**Ref: BE/17/18/PL - Mr & Mrs Clarke, 37 Norbren Avenue,
Bognor Regis, West Sussex**

We strongly object to the building of the proposed bungalow on the small piece of garden between 37 Norbren Avenue and 53 Greencourt Drive as set out below.

Proposed Ground Floor Plan

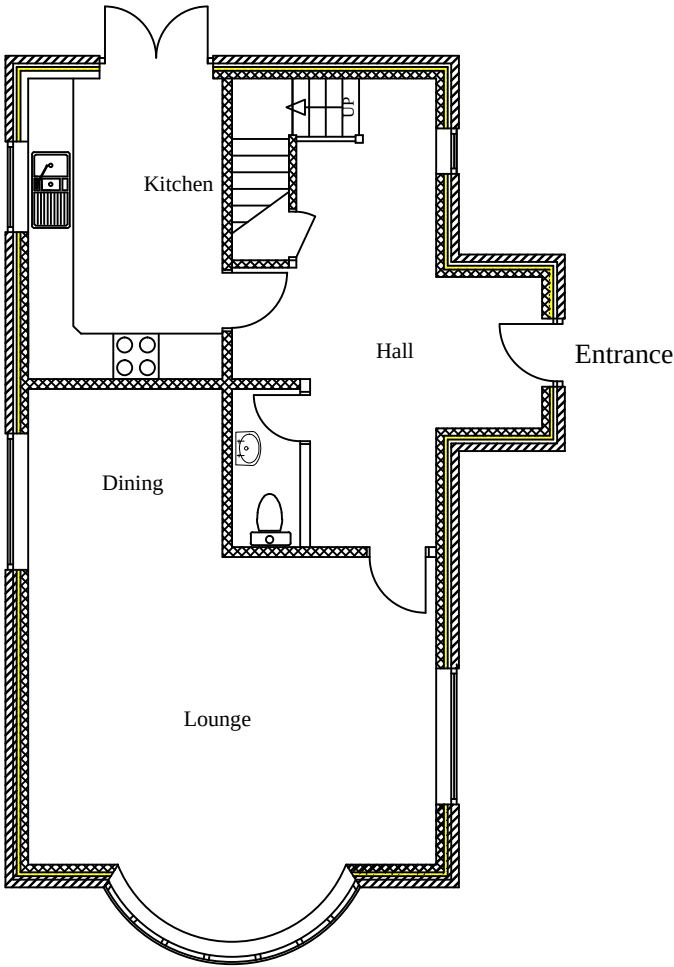
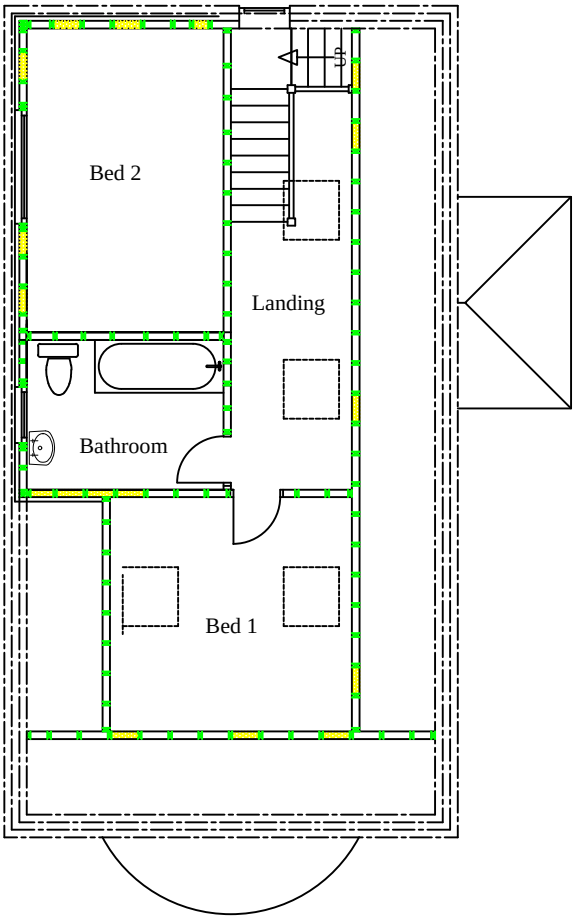
We already experience parking difficulties in this road, made increasingly difficult with the number of vehicles parked at 37 Norbren Avenue at any one time. Currently there are four/five cars, three of which are permanently on the road, one parked almost on the corner of Norbren Avenue, this one rarely moves. Also the number of vehicles parked at this property increases on occasions thereby causing even more problems. There is also a caravan at the property which again can cause obstruction when being moved, together with a boat. We are very concerned that if this proposed bungalow is built there will be even more problems with vehicles, the new owners/renters possibly having vehicles themselves. Just where are all these vehicles going to park. It is also noted from the plans that the proposed new bungalow has only a limited hard standing.

Proposed Front Elevation (West)

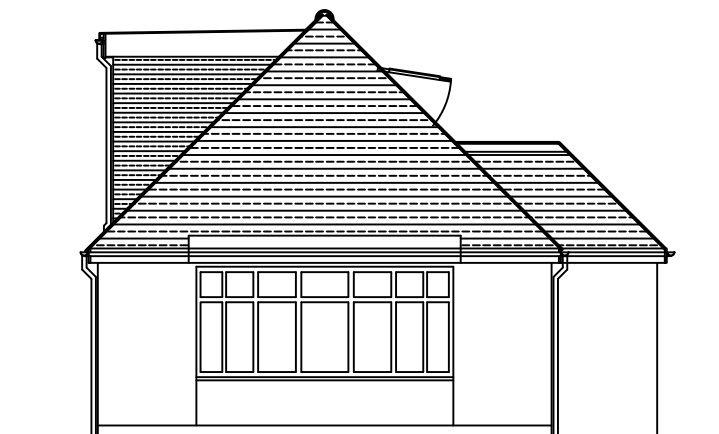
We note from the plans that the building line of the bungalow is proud of the building line of the rest of the houses in Norbren Avenue and looks totally out of place. This estate is made up of 1930's houses, a bungalow would be totally out of keeping with the rest of the properties. We are also concerned that the construction materials may not be aesthetically correct and in keeping with the other properties in the area. The bungalow would also appear to front very close to the public footpath in Norbren Avenue, which with the additional vehicle parking could present safety issues for pedestrians.
